DEVIATION REVIEW AND DECISION FORM

DEV18005

FLYING HORSE NORTH
(Horizontal Alignment)

FLYING HORSE NORTH FILING NO. 1
STREET IMPROVEMENT PLAN
LONGWALL DRIVE
(STA. 11+50.00-STA. 23+05.92)

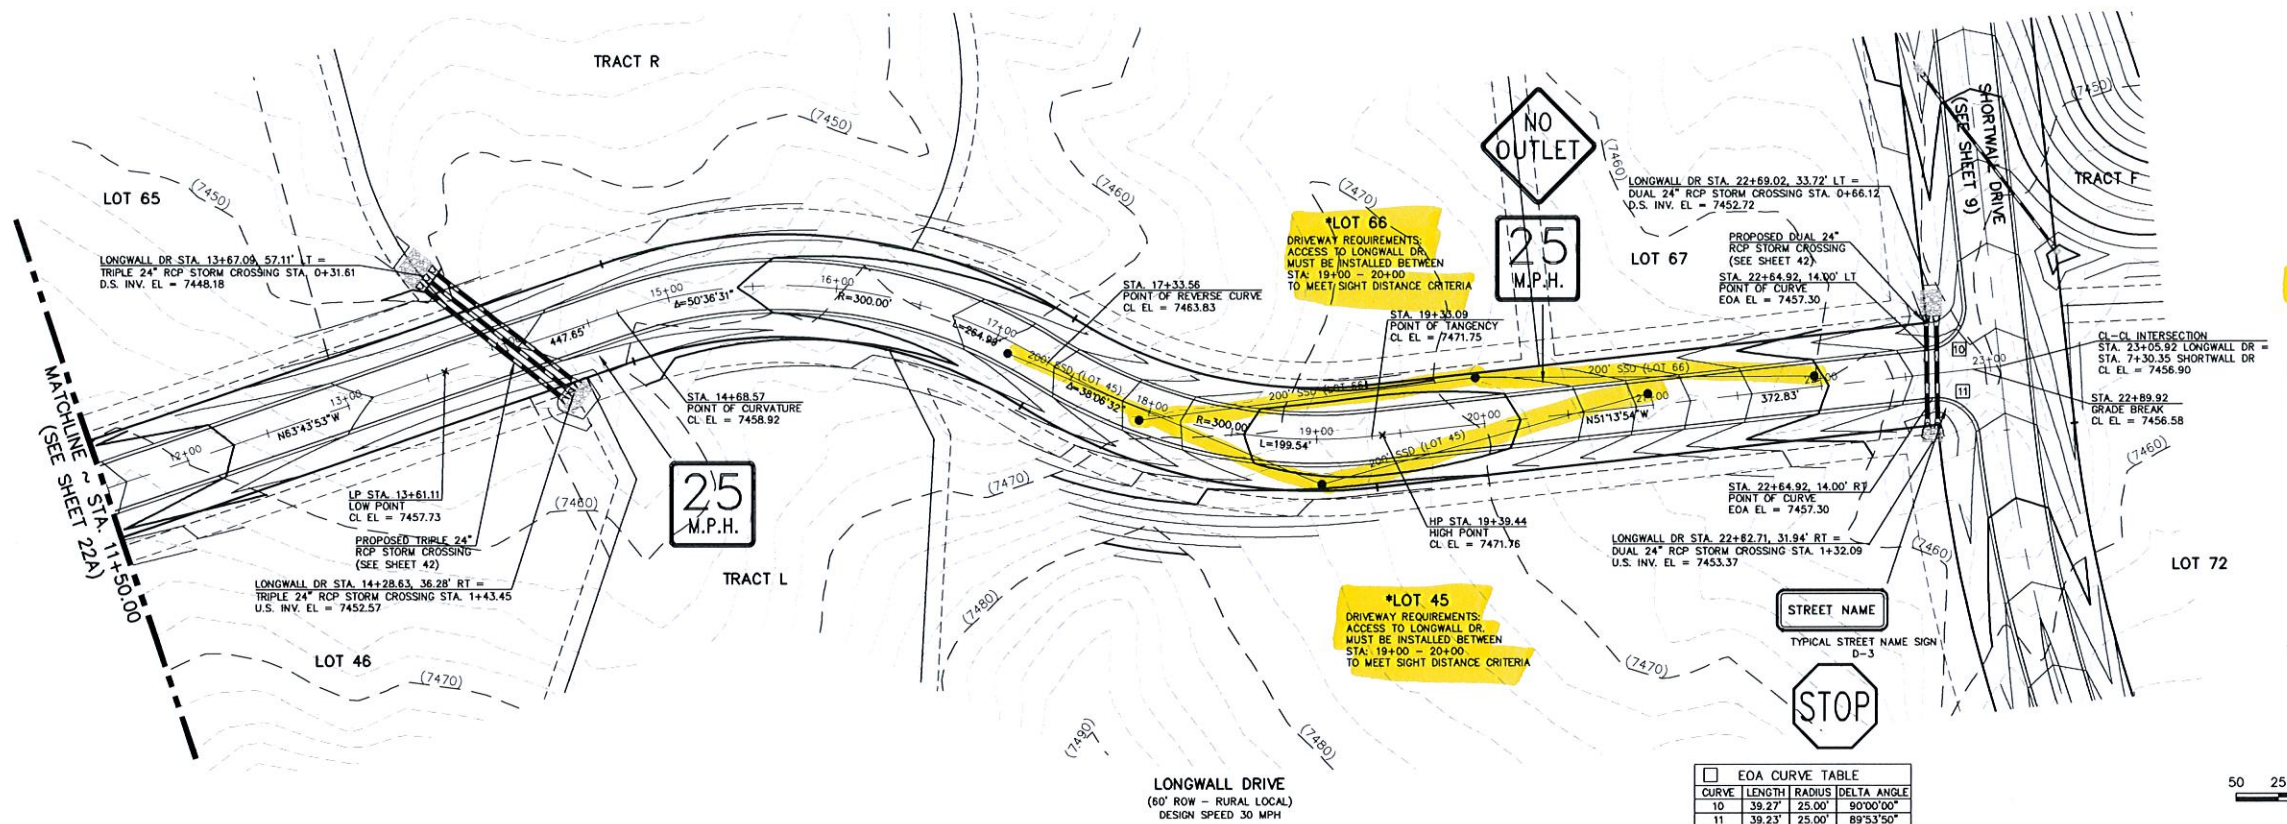
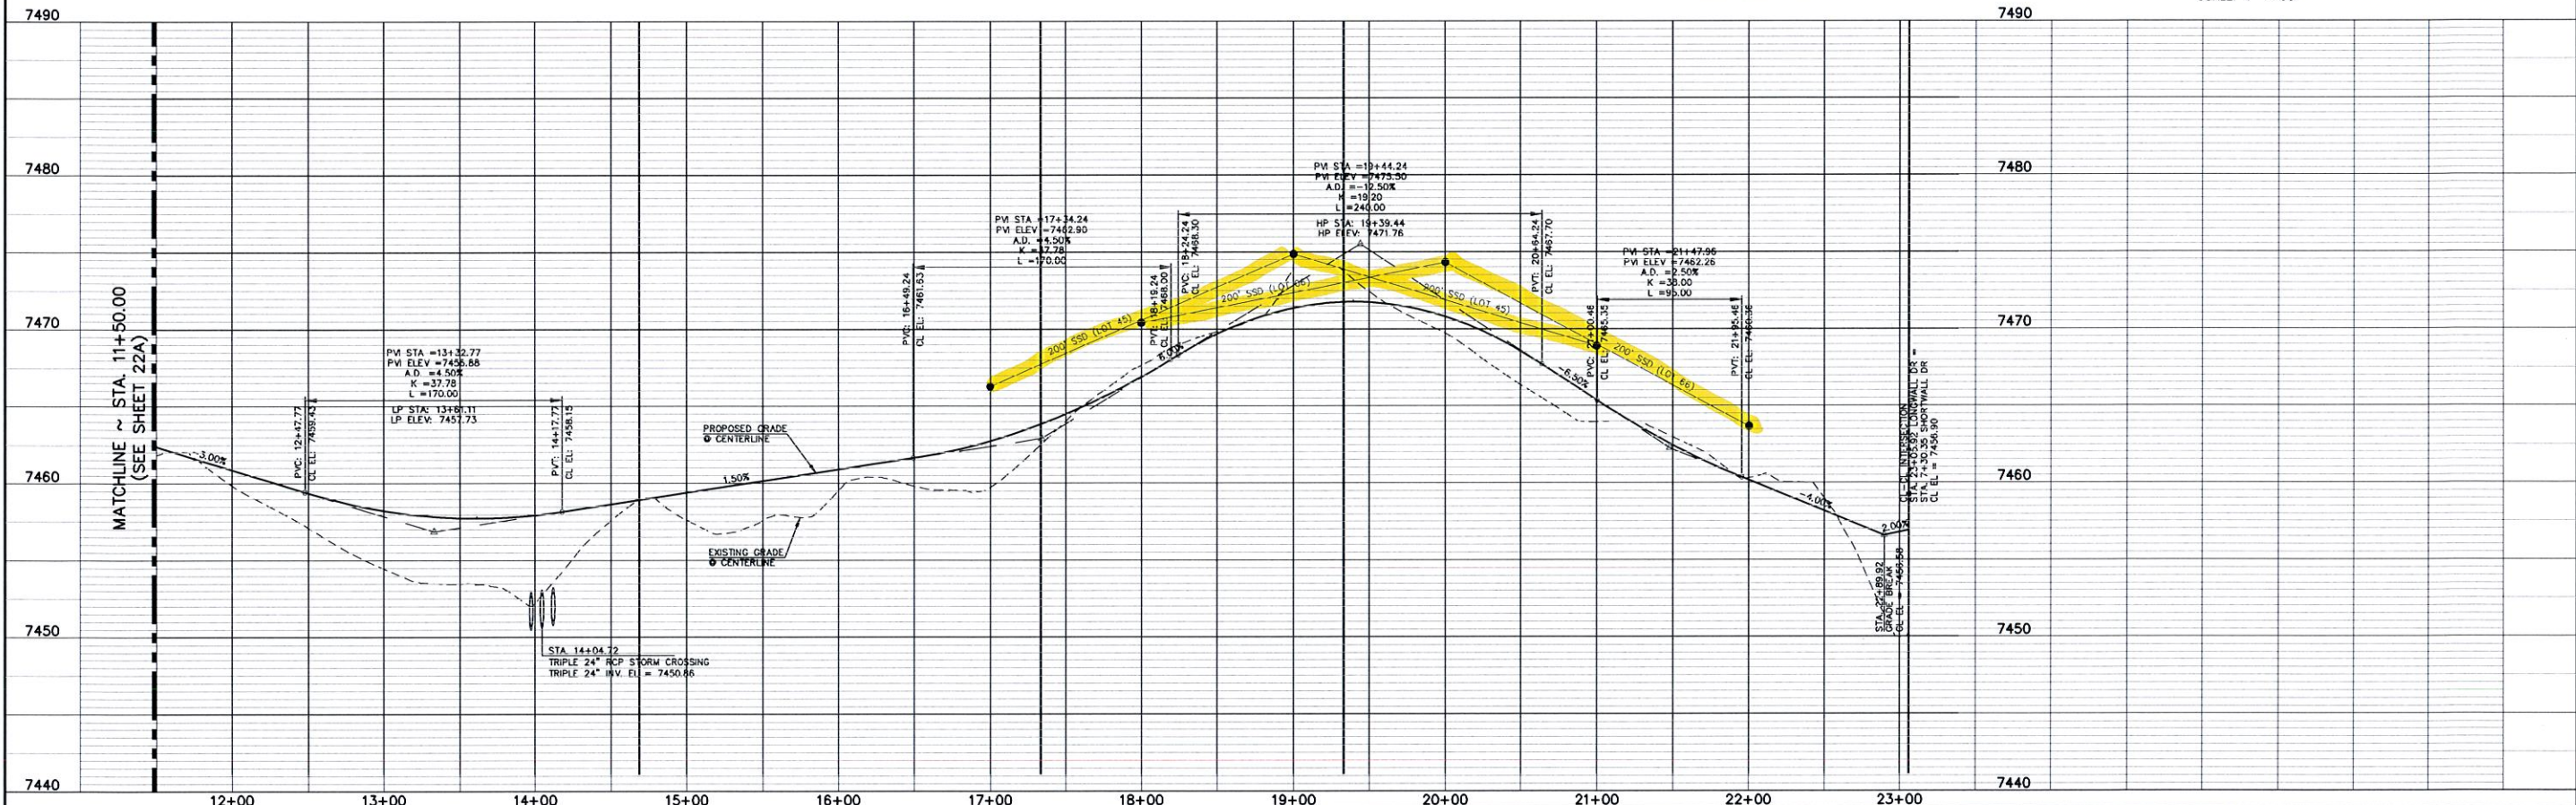
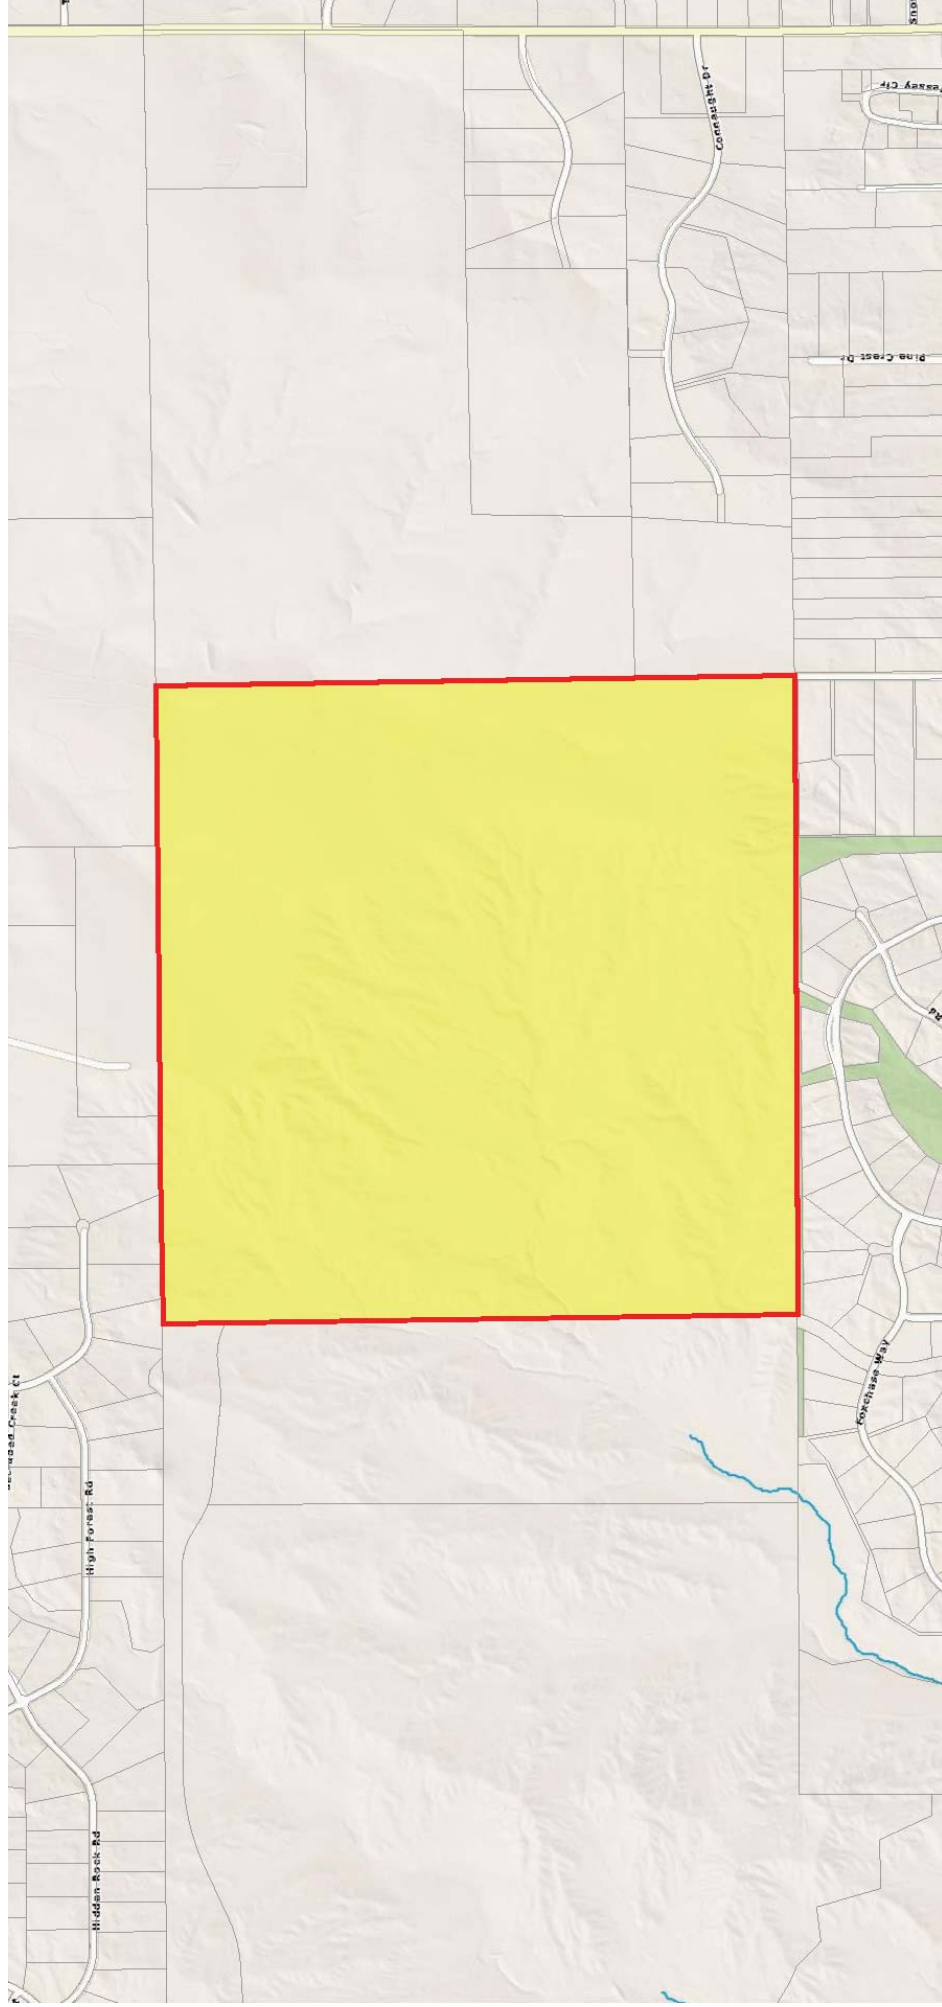
For Longwall Ct no comparable or superior design has been proposed. Specify how the applicant plans to mitigate the impact if the deviation is approved?

this proposed mitigation will be reviewed on the next submittal once an exhibit is submitted.

Provide sight distance exhibit for the adjacent lots. Limitations to the driveway locations will need to be identified with the deviation request as part of mitigating safety concerns.

Driveway sight distance is not met at specific locations. Example: Driveway sight distance criteria for lot Lot 66 will not be met if located near station 17+00.

FLYING HORSE NORTH FILING NO. 1 STREET IMPROVEMENT PLAN OLD STAGECOACH ROAD - MINOR COLLECTOR STA. 3+55.28 - STA. 16+00.00			
DESIGNED BY	PRA	SCALE	DATE 08-11-17
DRAWN BY	PRA	(H) 1" = 50'	SHEET 11 OF 58
CHECKED BY		(V) 1" = 5'	JOB NO. 1096.11

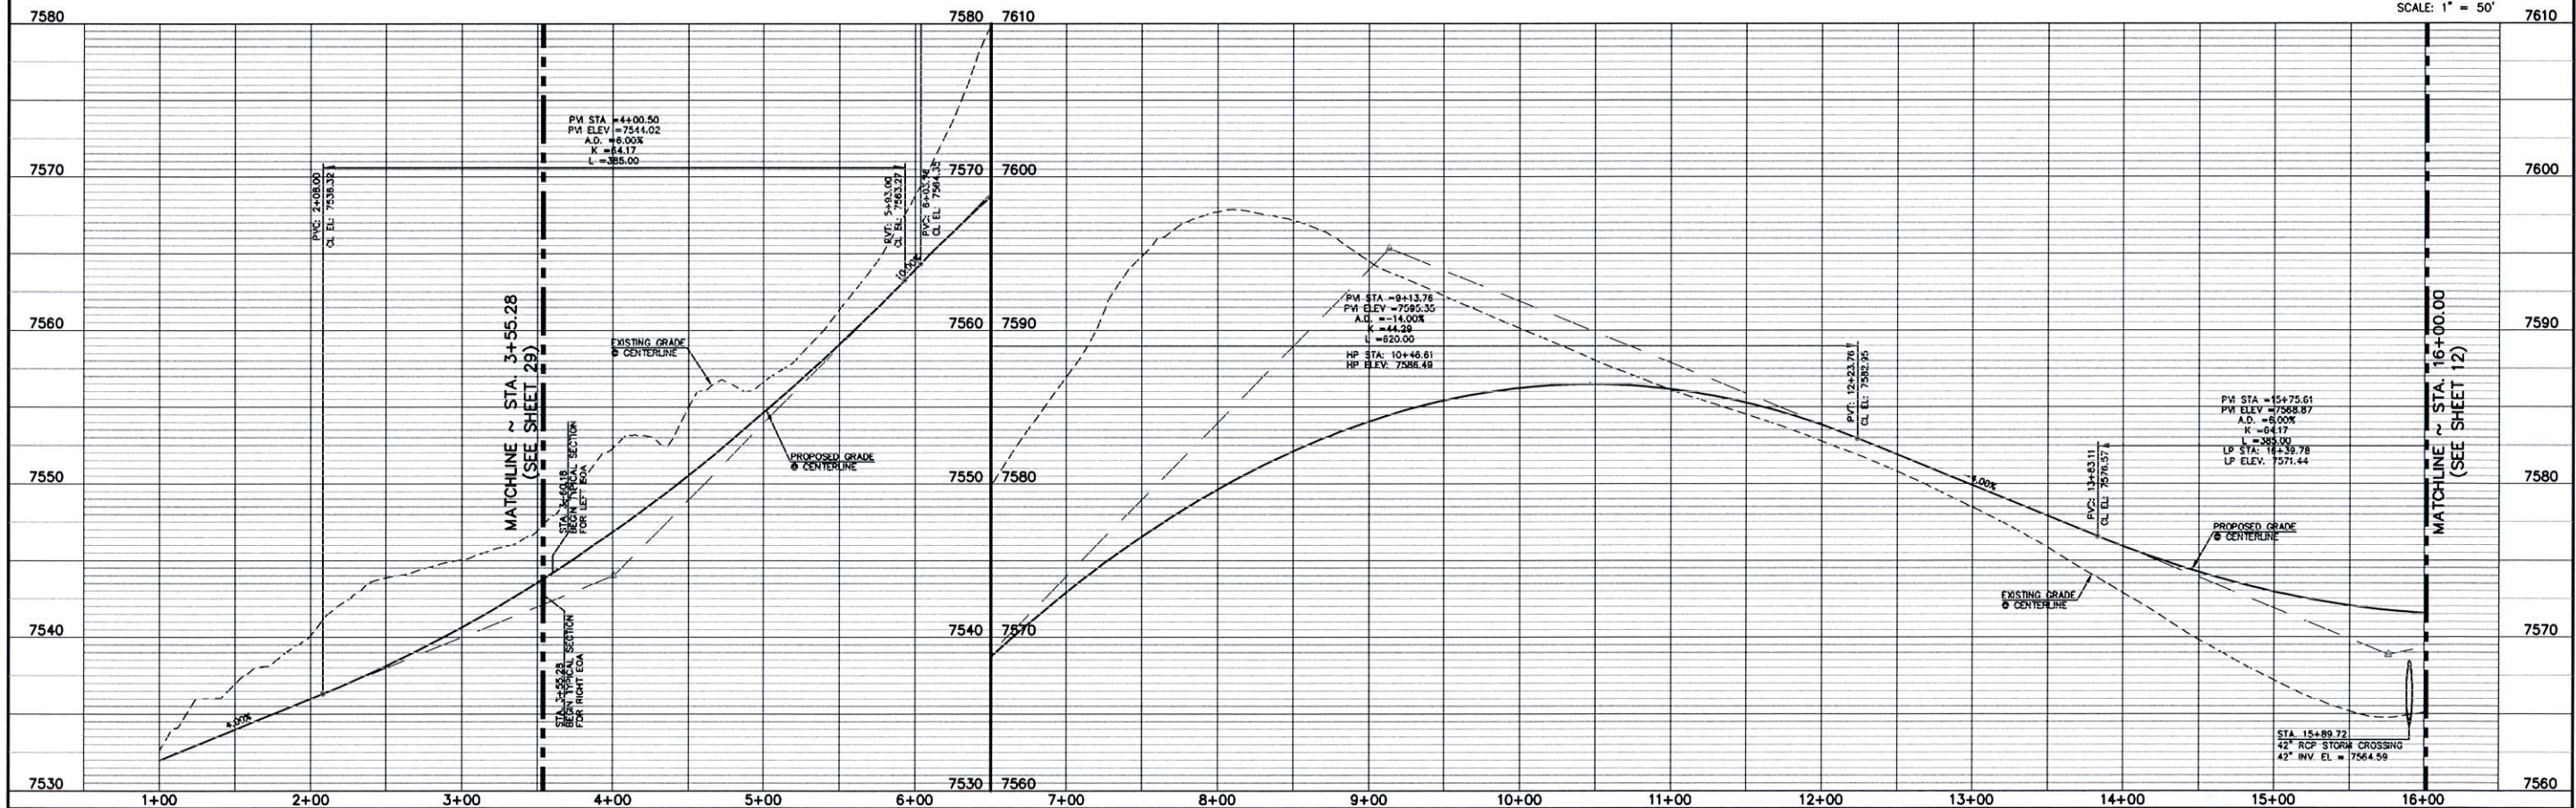
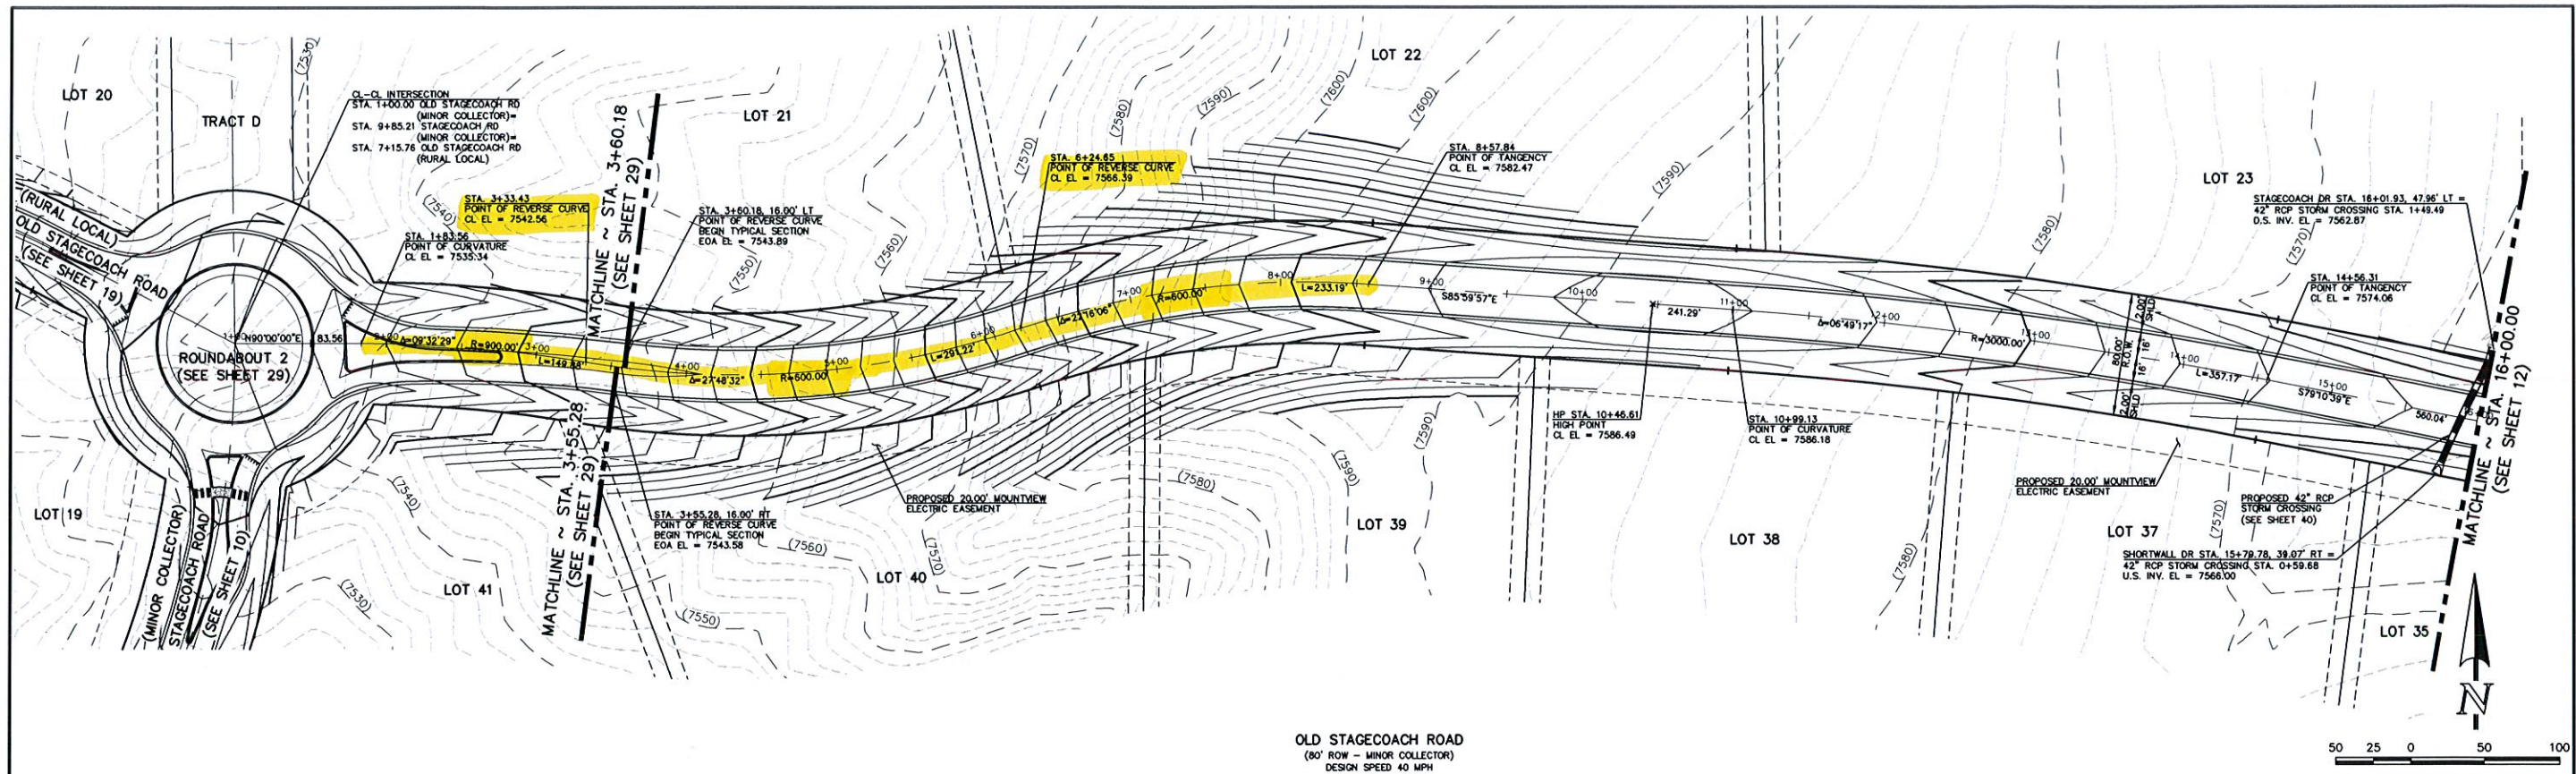
Proposed Nature and Extent of Deviation: The nature of this deviation from the horizontal alignment criteria has to do with the hillside characteristics and forested vegetation in these specific areas in relation to the approved PUD Plan (PUD-16-002). A reverse curve is proposed on Old Stagecoach Road just east of the 2nd round-about and a horizontal curve near the high point of a vertical curve is proposed on Longwall Ct. just east of Shortwall Dr.
